3/2018/0263 The application is for the proposed conversion of and extensions to the former care home to create five dwellings AT 10 Knowsley Road Wilpshire

Wilpshire Parish Council object to the application.

drawing title: PROPOSED SITE PLAN		
scale: 1:200 @ A2		
drawn: DS	checked: PH	
date: 22/03/18		
project no: PHA/123	fig. no: 200	rev: -

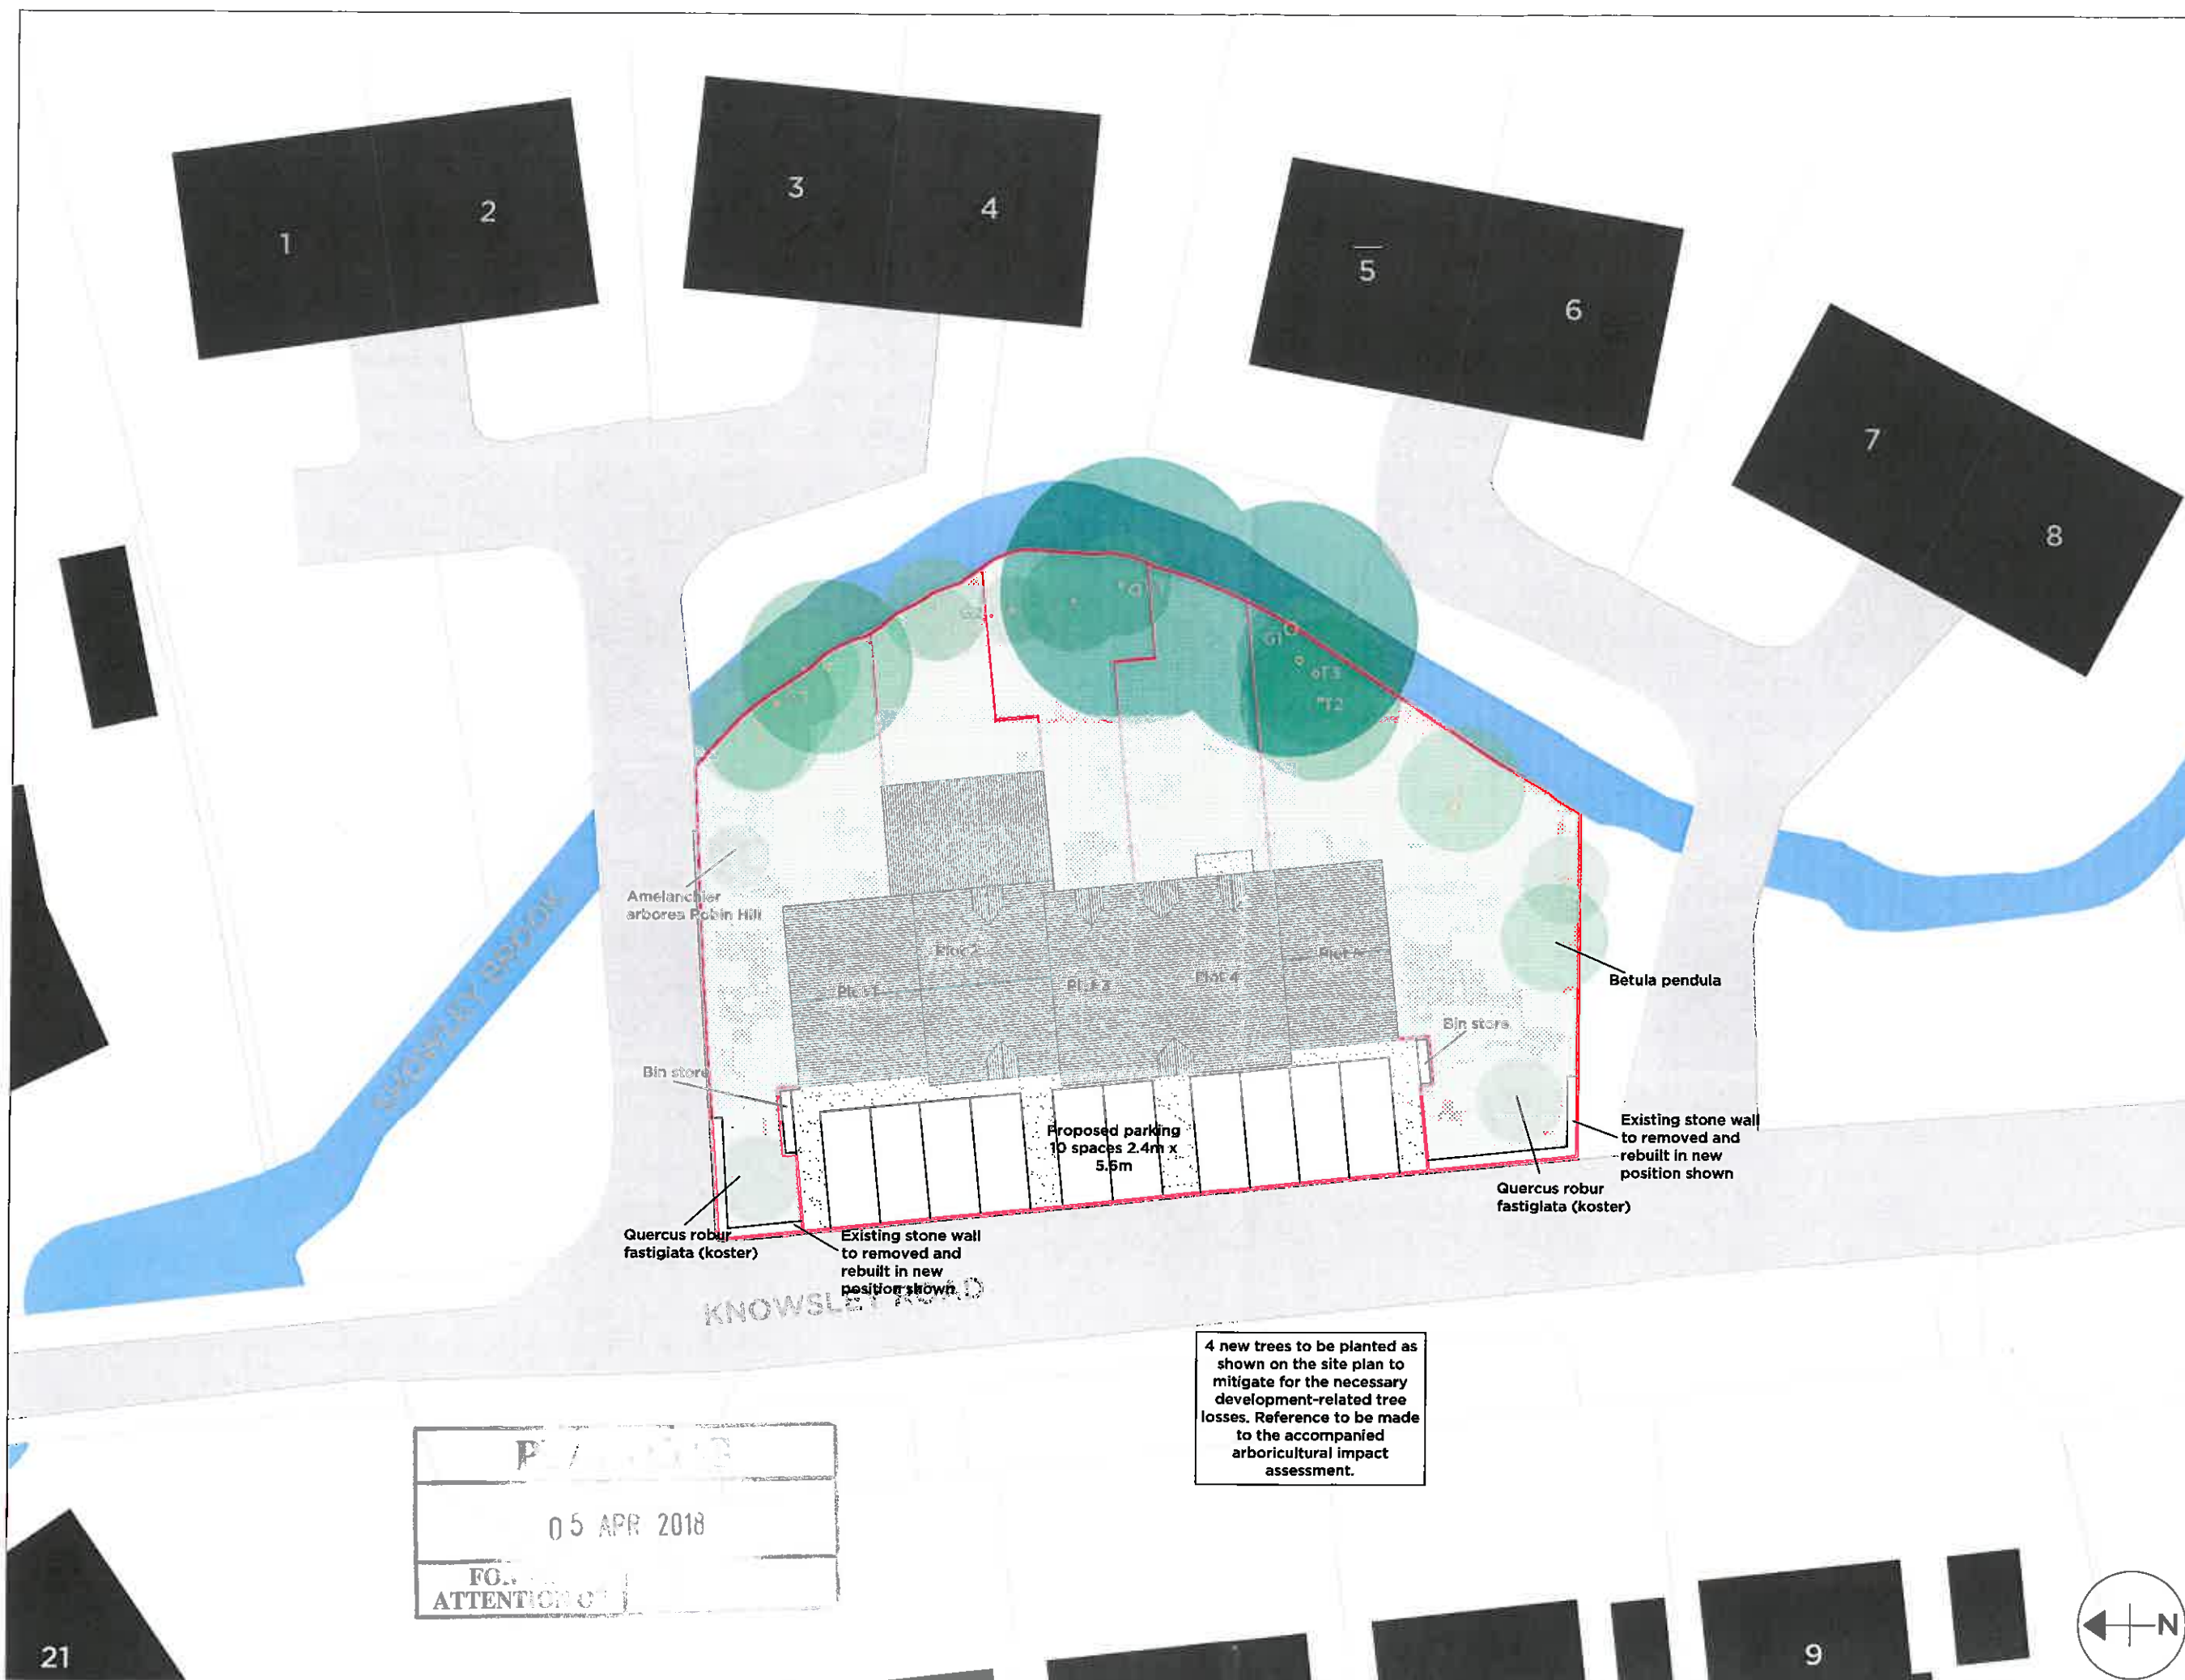
The proposal for the 10 parking spaces perpendicular to and right up to the carriageway would result in both an unacceptable degradation in the street scene and also be a significant road traffic hazard as exiting vehicles would have no space to lock round before being fully on Knowsley Road.

The parish council further feel that the extra dwellings at each end of the existing property could be seen as overdevelopment of the site.
